Our ref: DOC20/635611-1

Your ref: SSD 9526

Maxwell Underground Coal Mine Project (SSD 9526) – Supplementary Flora Surveys

Figure 3. Threatened Flora Species/Endangered Population

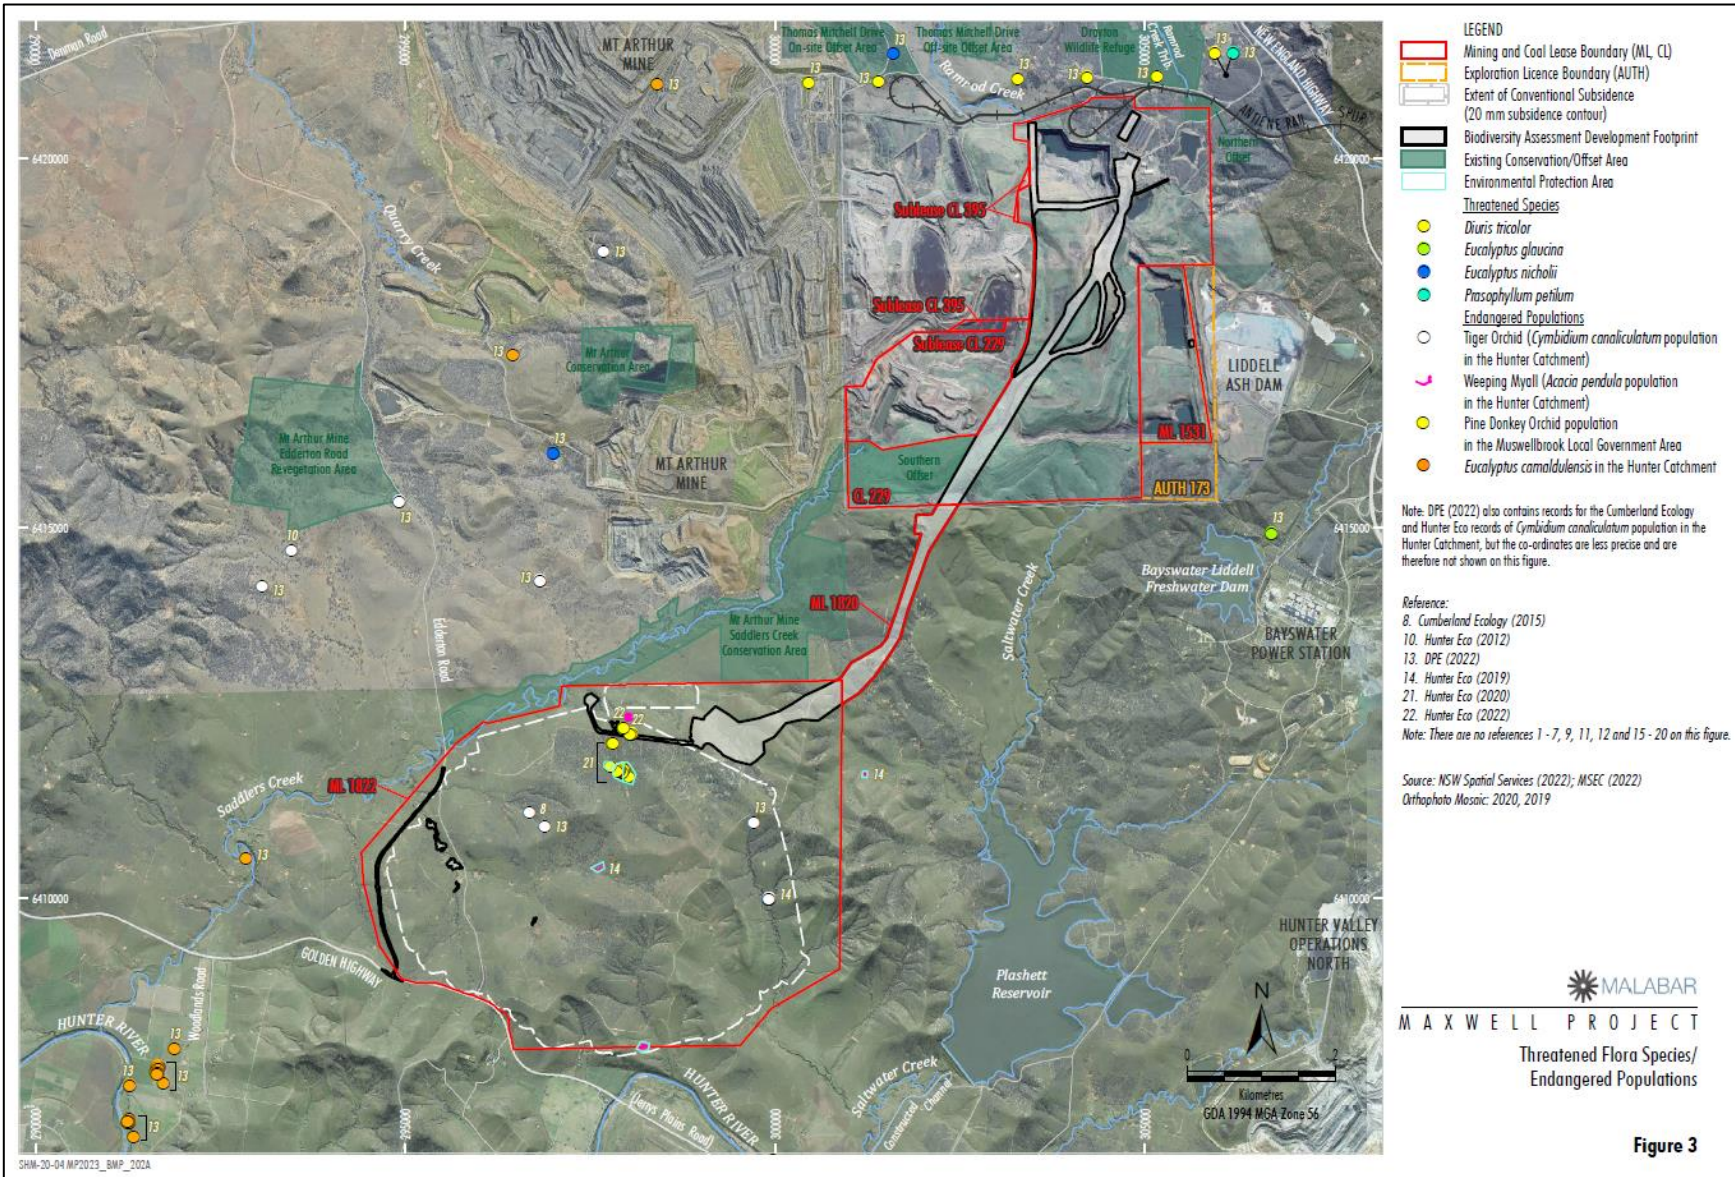
BCD has reviewed Hunter Eco's response and is satisfied that supplementary flora surveys have been sufficient to discount the presence of *Eucalyptus glaucina* and *Cymbidium canaliculatum* from the development footprint.

Survey transects undertaken for both *Ozothamnus tessellatus* and *Thesium australe* were spaced at 40 metres apart rather than the maximum of 20 metres or less apart, as specified in the *NSW Guide to Surveying Threatened Plants* (OEH 2016, the survey guidelines). As the surveys for both species were not undertaken in accordance with the survey guidelines, our previous advice stands.

To satisfy the survey guidelines, survey transects for *Ozothamnus tessellatus*, particularly when plants are not in flower, should be 20 metres or less apart. Survey transects for *Thesium australe* should be 20 metres apart or less to identify patches of *Themeda triandra* (in which *Thesium australe* occurs), followed by transects 5 metres apart within patches of *Themeda triandra* to look for *Thesium australe*.
